## **Net Zero Teesside Project**

Planning Inspectorate Reference: EN010103

**The Net Zero Teesside Order**

**Document Reference: 1.6 – Signposting Document for Updated Application Documents**

Figure 17-7a **DATE**

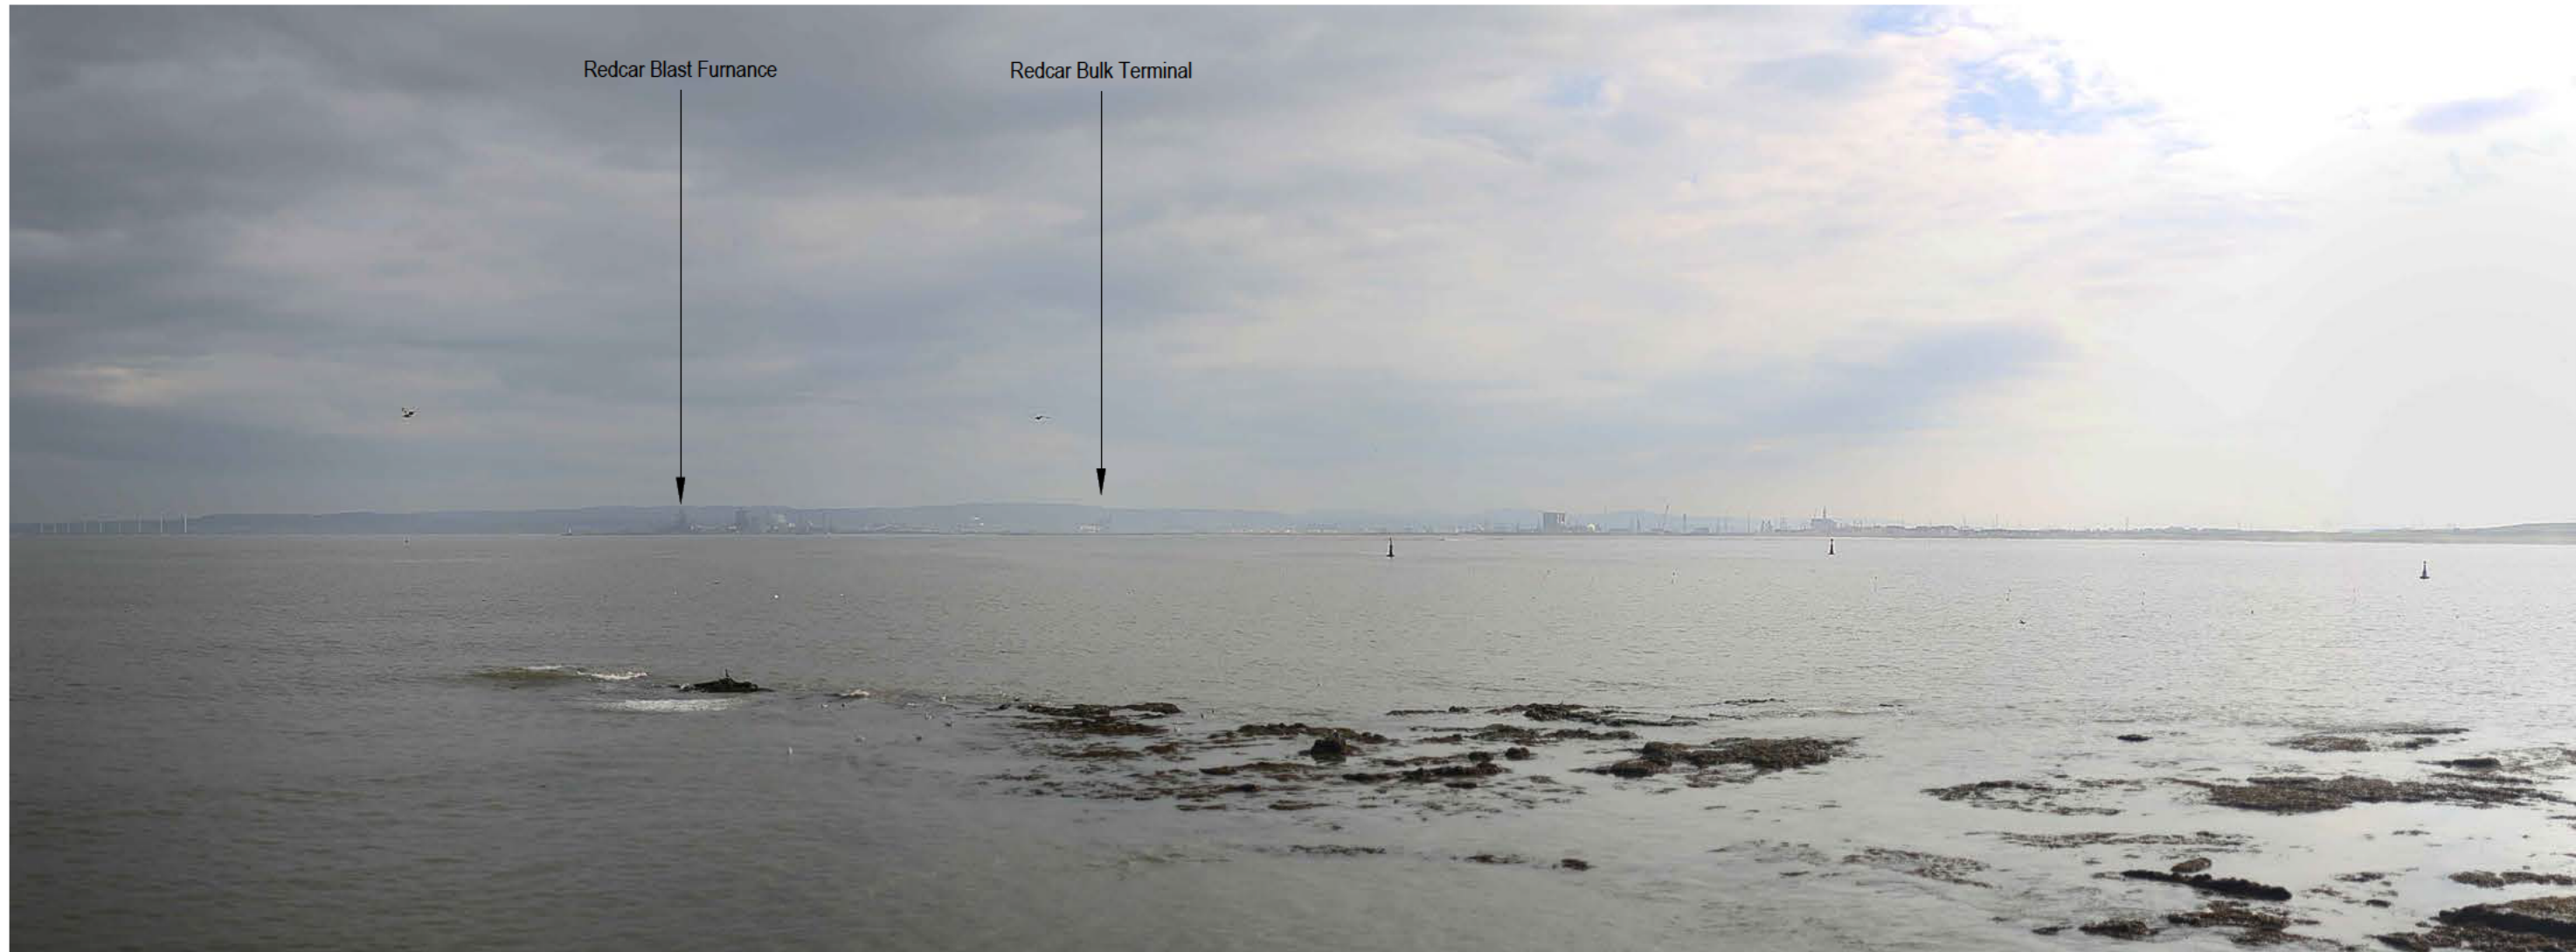
Submission of updated documents:		
The following documents are corrupt, the Applicant is requested to provide amended versions:  • 6.3.74 ES Vol II Figure 17-7a Viewpoint 1 – Albion Terrace Hartlepool (Summer).	The Applicants have submitted uncorrupted versions of the Project Need Statement, the Indicative Lighting Strategy and ES Vol II Figure 17-7a. Minor changes have been made to the Indicative Lighting Strategy (repagination and correction of a table reference).	Document Ref. 5.2 'Project Need Statement' – May 2021 Rev. 1.0  Document Ref. 5.8 'Combined Heat and Power Assessment' – October 2021 Rev. 2.0
